GRADING EROSION CONTROL PLANS

FUEL STATION #4335

11550 MERIDIAN MARKET VIEW

GRADING EROSION CONTROL COVER SHEET  
SHEET TITLE  
SHEET NUMBER

GRADING EROSION CONTROL COVER SHEET
SHEET TITLE
SHEET NUMBER

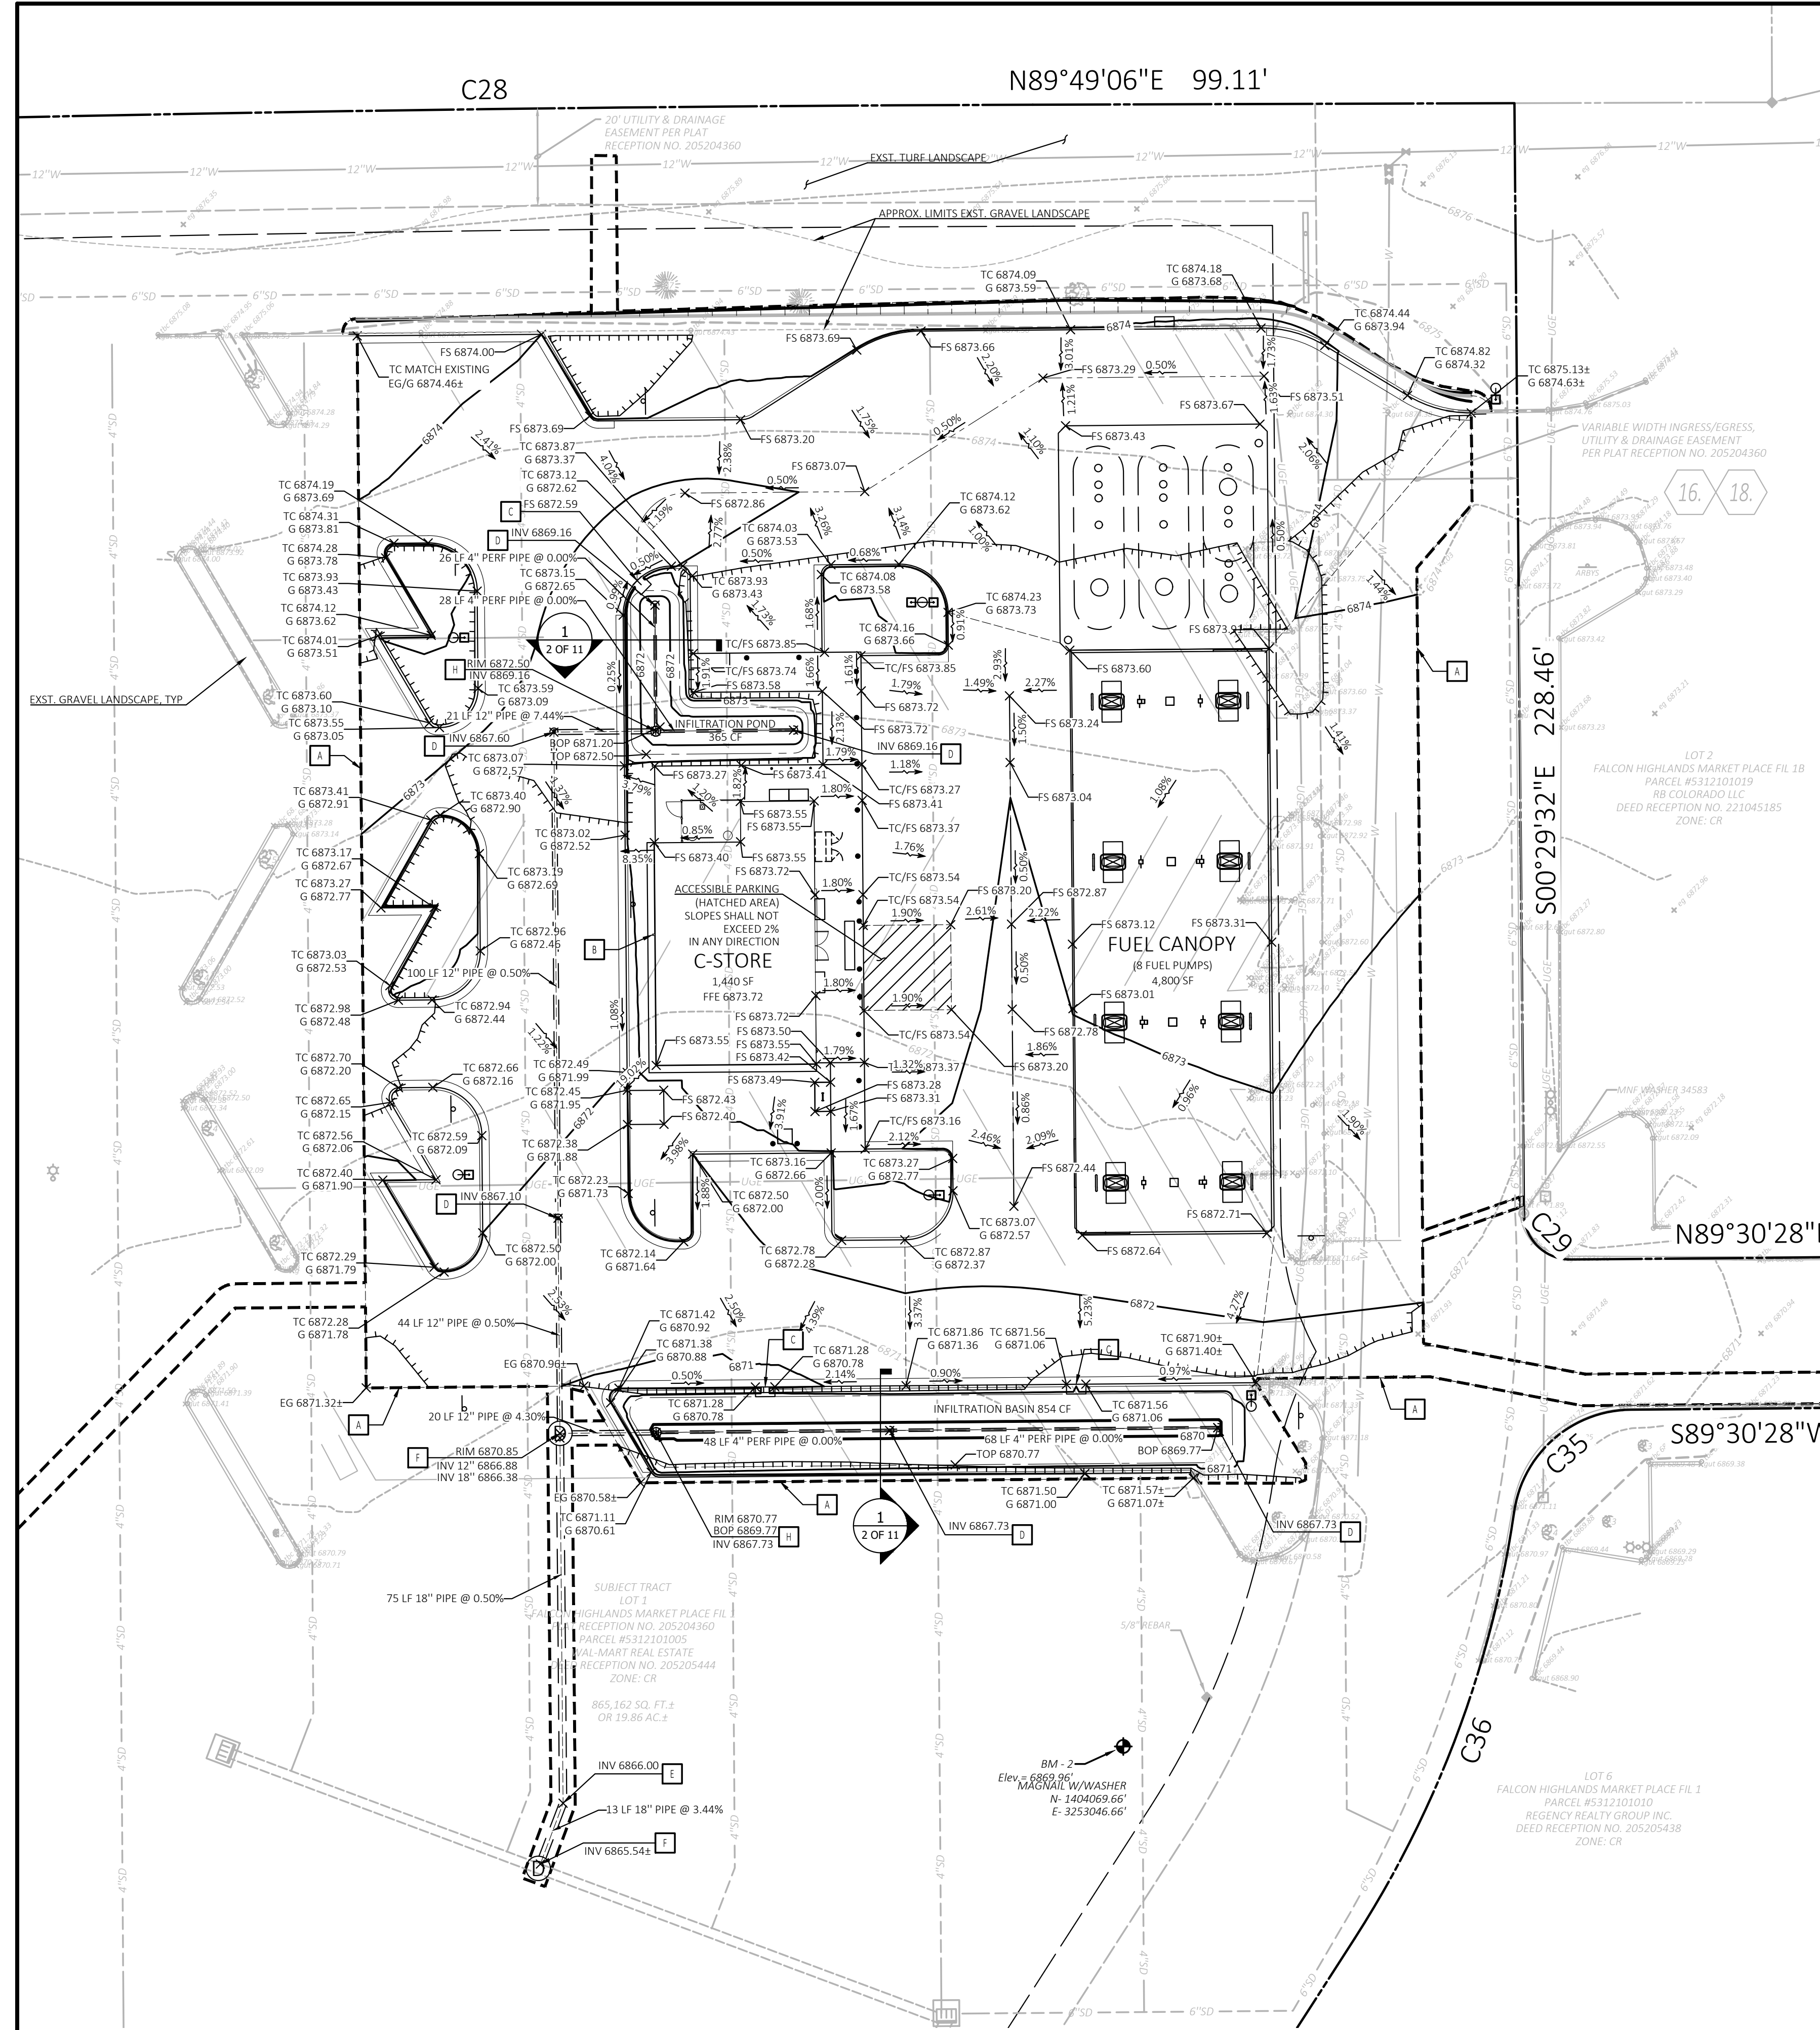
Revise to "Joshua Palmer, P.E."

Add text:  
EPC's EDARF Filing #:  
PPR2324
